# OXFORDSHIRE COUNTY COUNCIL'S RESPONSE TO CONSULTATION ON THE FOLLOWING DEVELOPMENT PROPOSAL

**Application no:** 21/04275/OUT

**Proposal:** OUTLINE - with all matters reserved except for Access - Mixed Use Development of up to 3,100 dwellings (including extra care); residential and care accommodation(C2); mixed use local centre (comprising commercial, business and service uses, residential uses, C2 uses, local community uses (F2(a) and F2(b)), hot food takeaways, public house, wine bar); employment area (B2, B8, E(g)); learning and non-residential institutions (Class F1) including primary school (plus land to allow extension of existing Gagle Brook primary school); green Infrastructure including formal (including playing fields) and informal open space, allotments, landscape, biodiversity and amenity space; burial ground; play space (including Neaps/Leaps/MUGA); changing facilities; ground mounted photovoltaic arrays; sustainable drainage systems; movement network comprising new highway, cycle and pedestrian routes and access from highway network; car parking; infrastructure (including utilities); engineering works (including ground modelling); demolition

**Location:** Adj Lord

TITLE:
PROPOSED SIGNALISED JUNCTION 31

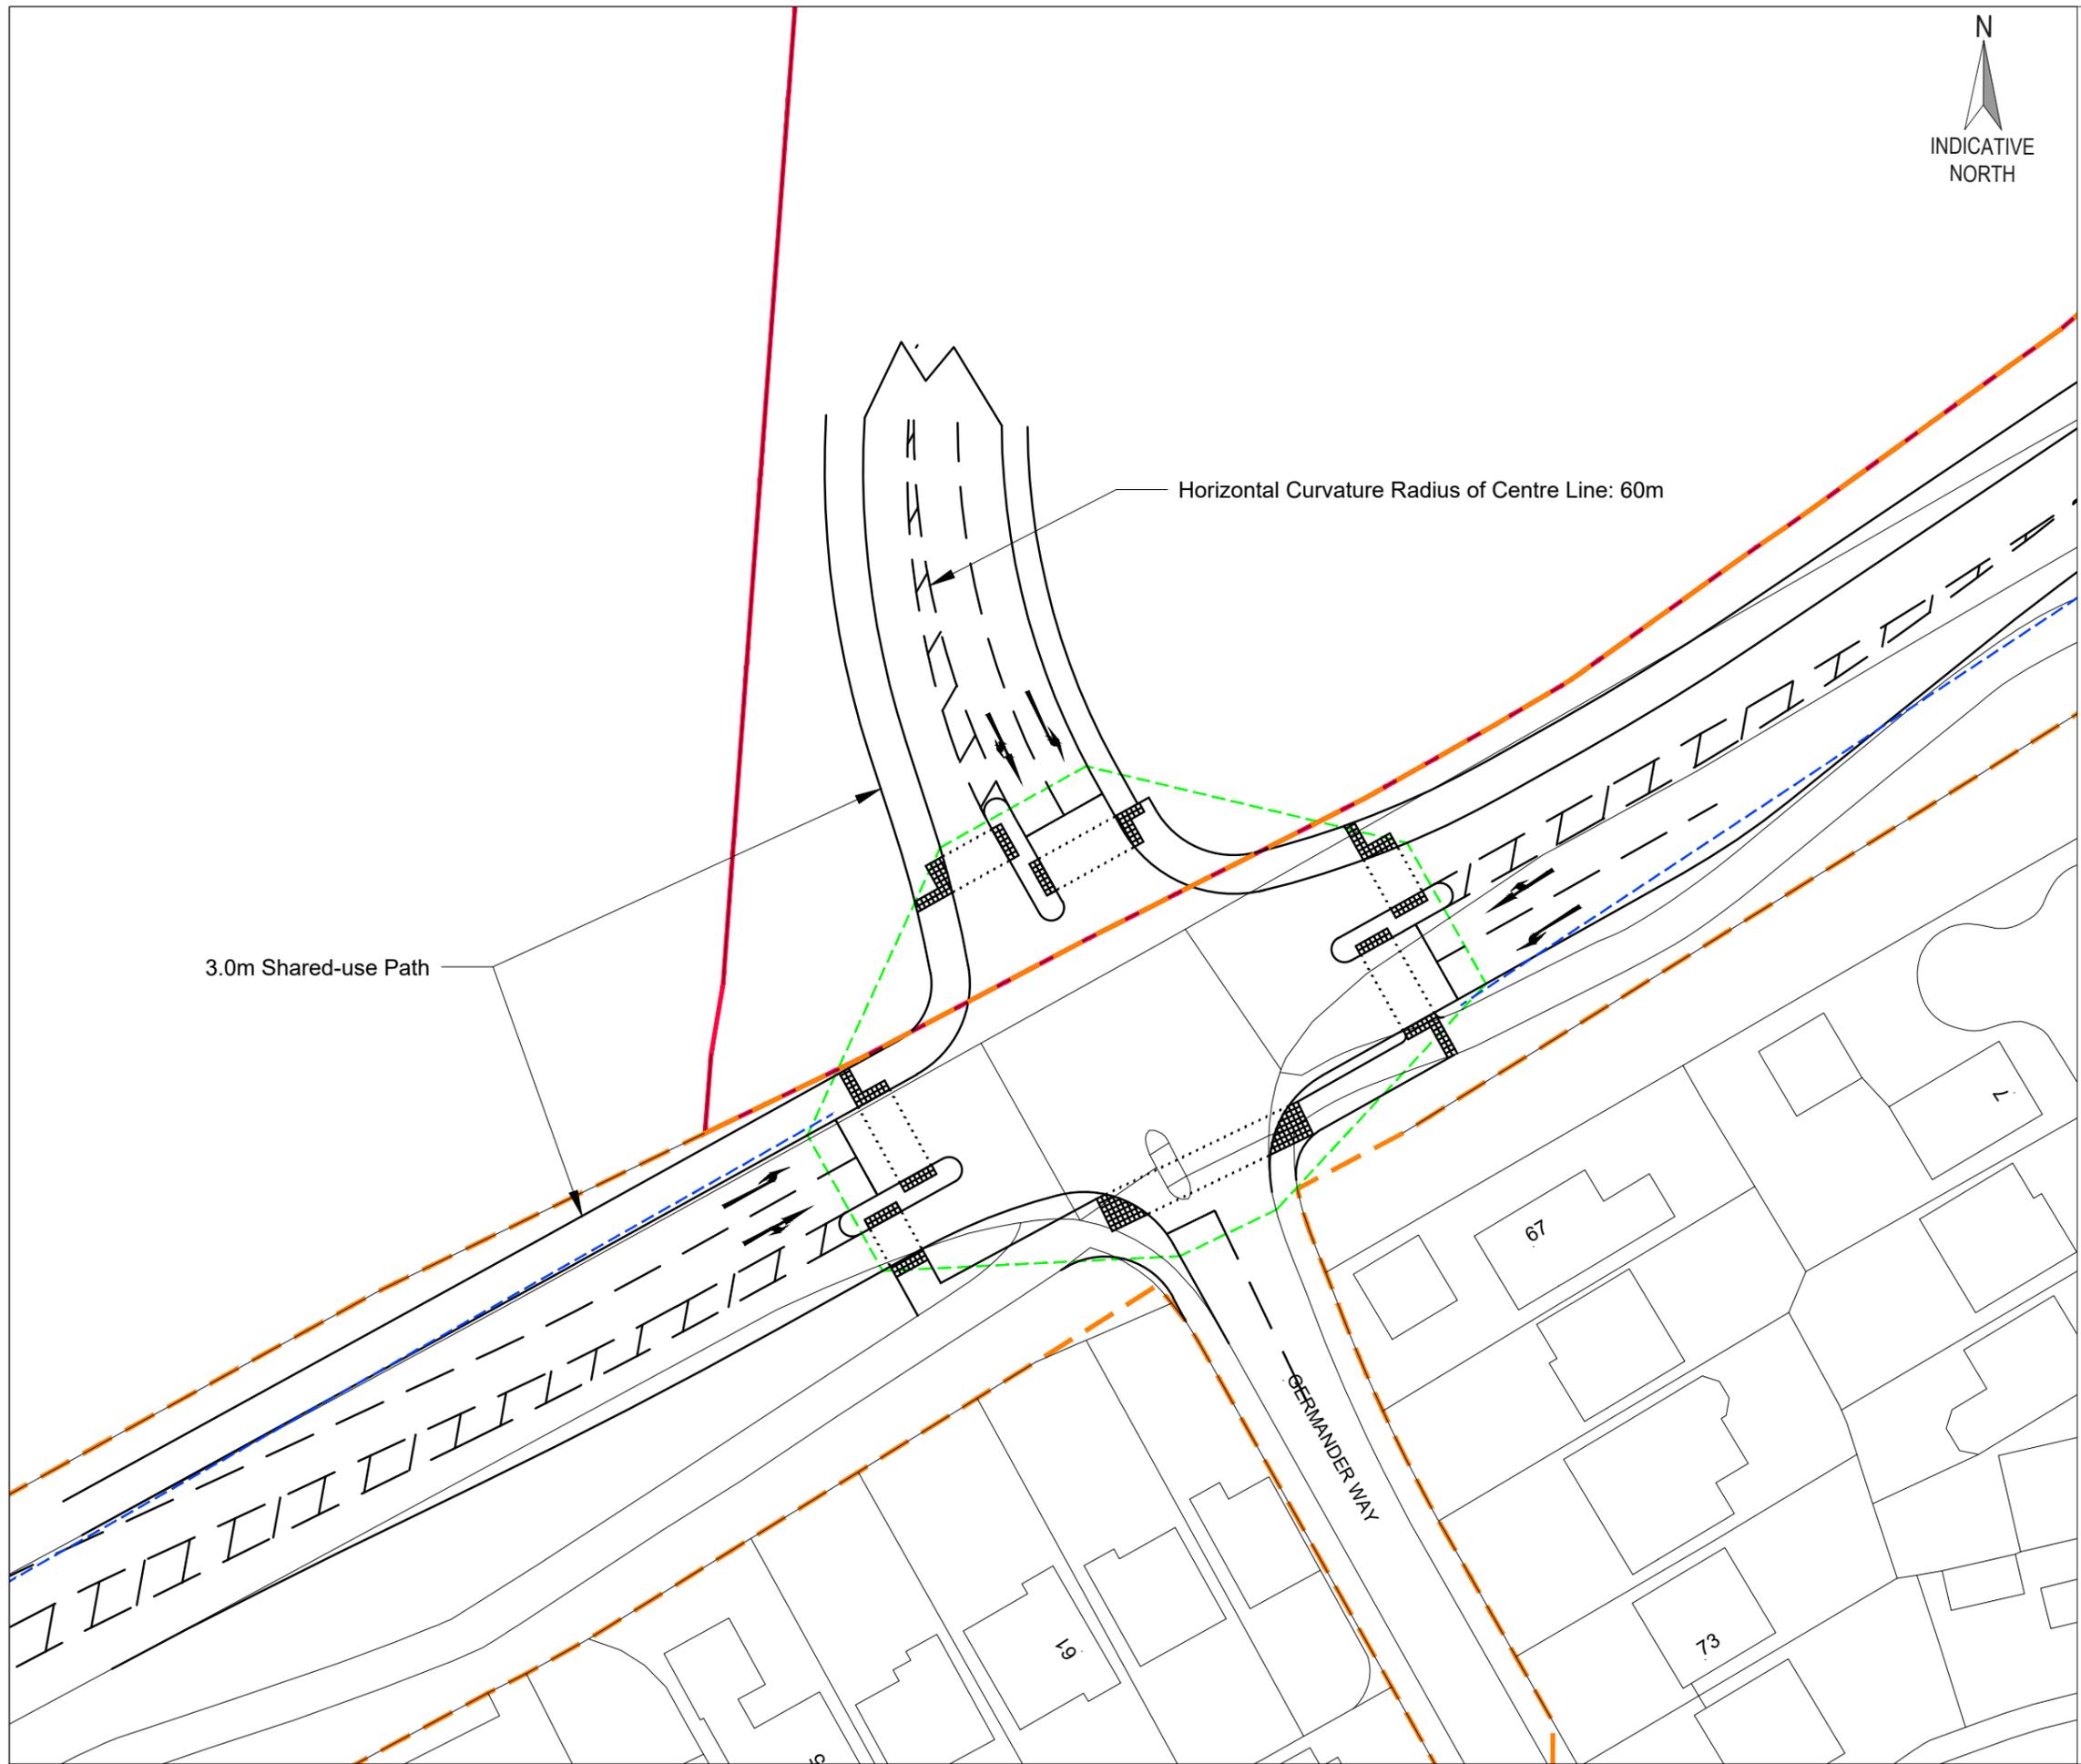
OCC policy supports the introduction of straight over crossings for cyclists and a phase that is all red to motor traffic. This will also benefit pedestrians, and reflects our LTCP policy to prioritise the movement of pedestrians and cyclists over motor traffic. Further discussions are recommended on the design of the junctions but our preference would be for cycles to cross closer to the stop lines than cyclists.

The layout of the western access junction needs to take into account the design of the SLR (A4095 realignment) and the placing of junctions on it, which has not yet been agreed.
